**Subject:** FW: 22/03873/F - Land North And Adjacent To Mill Lane, Stratton Audley

Having considered the LVIA I confirm the following response. This is a comprehensive and proportionate LVIA with an acceptable methodology based on the guidance of GLVIA3.

Client
JBM
Project:
Padbury
Drawing Title:
Site Layout Plan - 1 of 4
Drawing No: 1051745-ADAS-XX-XX-DR-PL-8001
Scale: 1:1000 at A1
Drawn by: A.F. Date: 26/07/22
Checked by: D.H. Date: 26/07/22

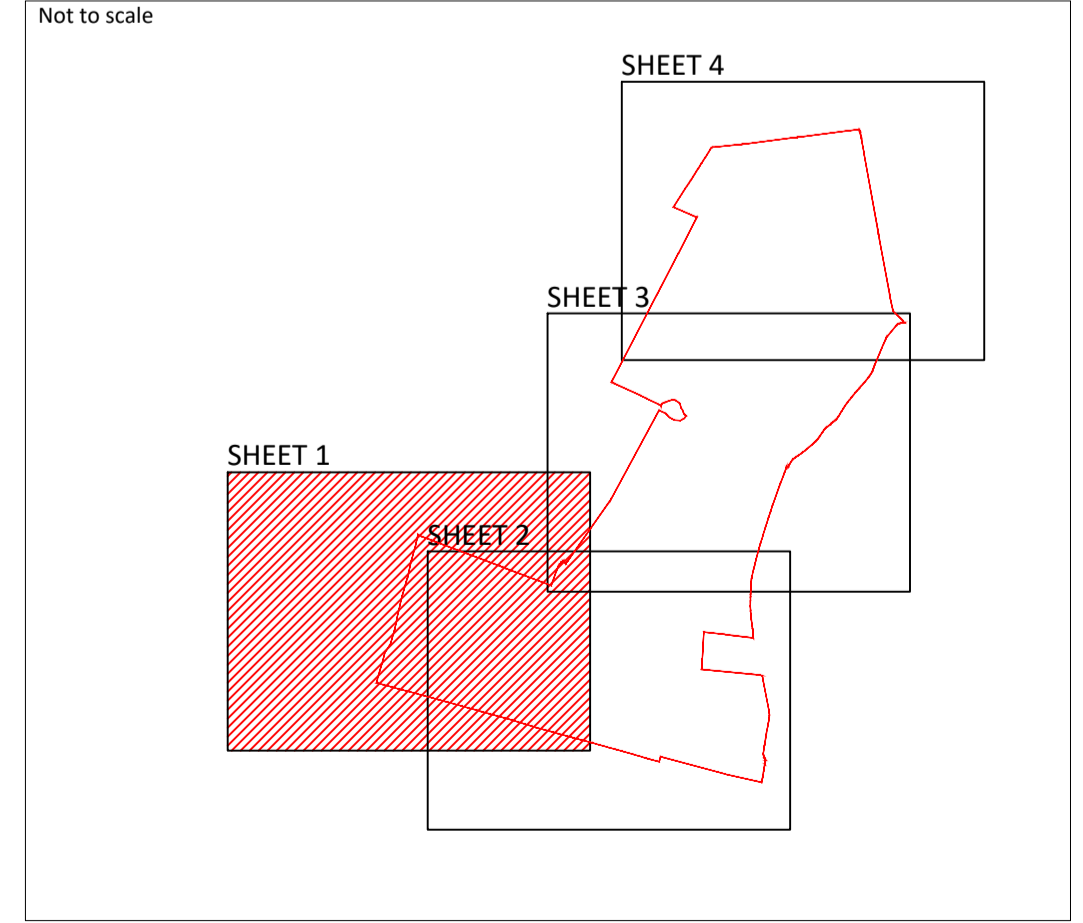
Note the minimum maintenance height of the new and existing hedgerows are to be confirmed to ensure that the appropriate level of screening is required. With the maximum height of the solar panels at 3 m were the most crucial visual impacts are experienced for visual receptors on the most sensitive PRoW, e.g. VP 5 and VP6, and the potential visual harm caused by reducing the height of hedgerow to below 3 m. A 3 m minimum hedgerow height should be stipulated.

\*Where the southern boundary of the eastern field parcel is defined by a low hedgerow which means roadside users and potentially sensitive visual receptors from the elevated Poodle Wood will experience visual harm, which means this hedgerow must be drawn on the landscape proposals, along with hedgerow trees. The hedgerow to be maintained to a minimum of 3 m
